Portland Water District

July 26, 2016

Attn: Jon Whitten
Re: 30 Merrill Street - Portland
Ability to Serve with PWD Water

C1

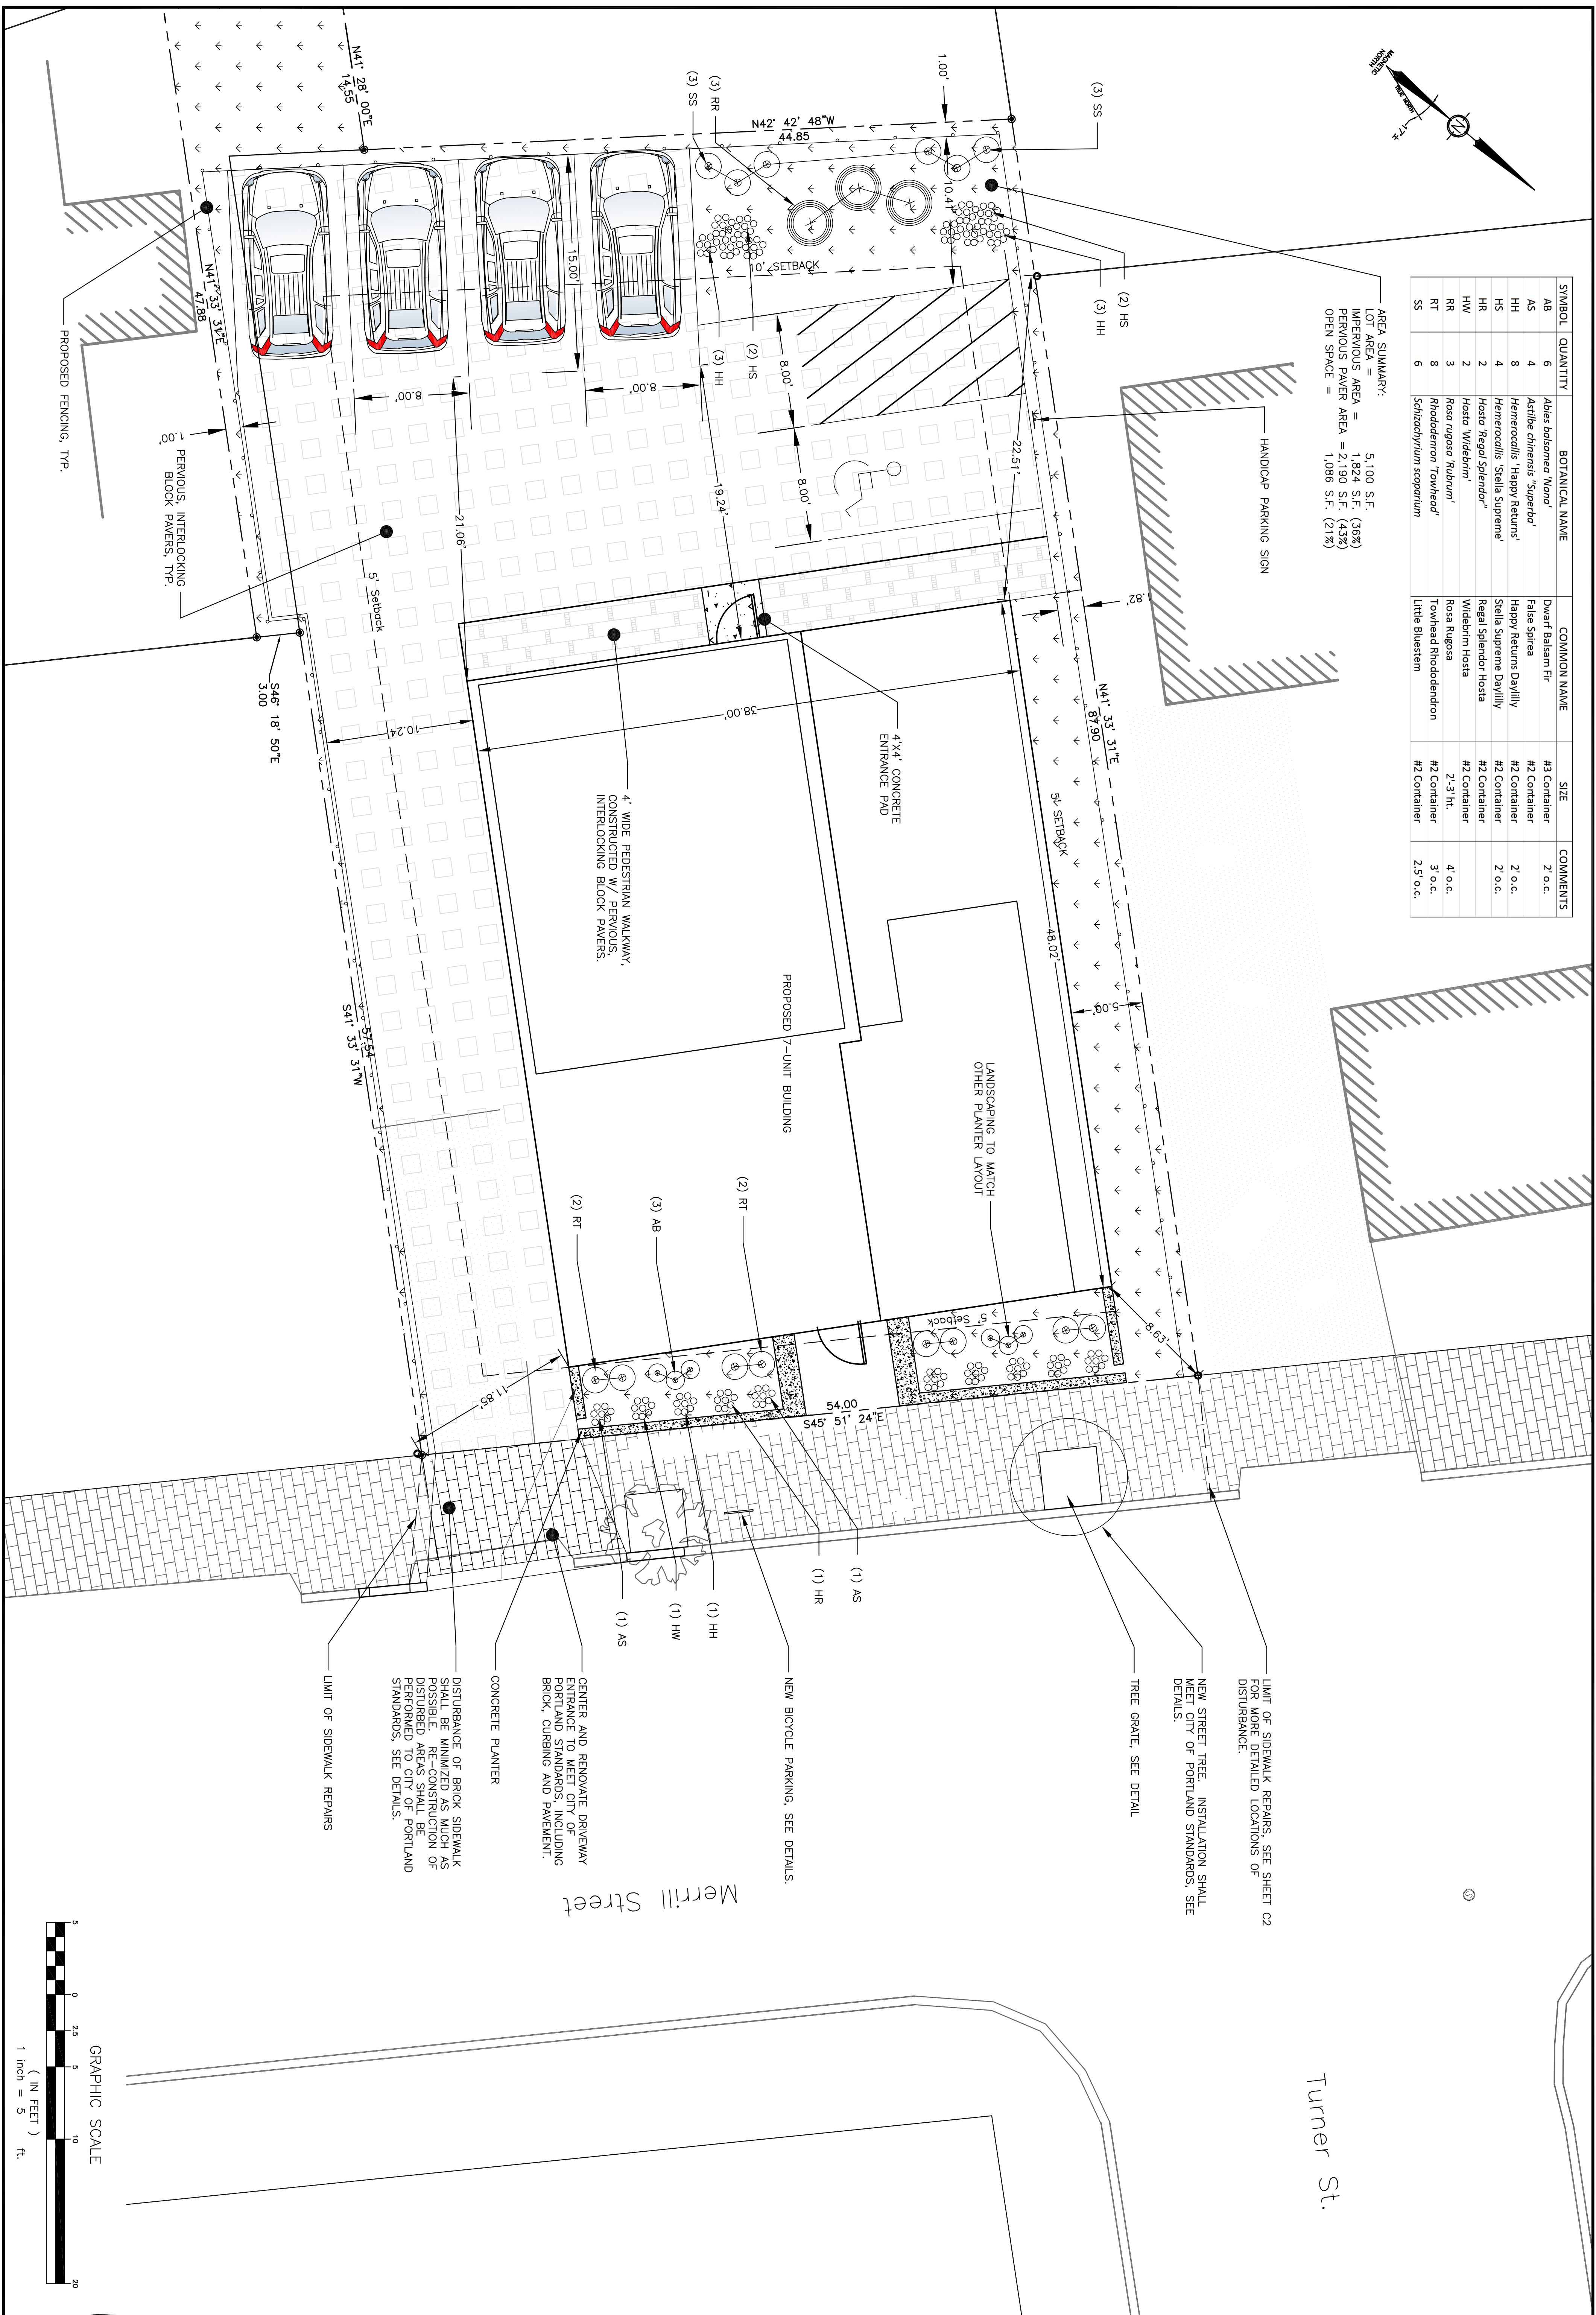
- A new 4" fire service may be installed from the water main in Merrill Street. A 2-inch domestic service may be tapped off the 4" fire service just before the street line as shown on a plan entitled Seven Unit Building, 30 Merrill Street, Sheet C1. Based on the fixture count you provided, we have calculated a peak flow of 25 gallons per minute. A 3/4" meter will accommodate this flow.

- We will need written confirmation from the sprinkler company that this configuration is acceptable to them.
- The existing building is currently served with a 3/4-inch domestic water service. The size of this service is undersized for the proposed use. This service must be terminated by shutting the corporation valve, cutting the pipe from the water main and removing the curb stop.
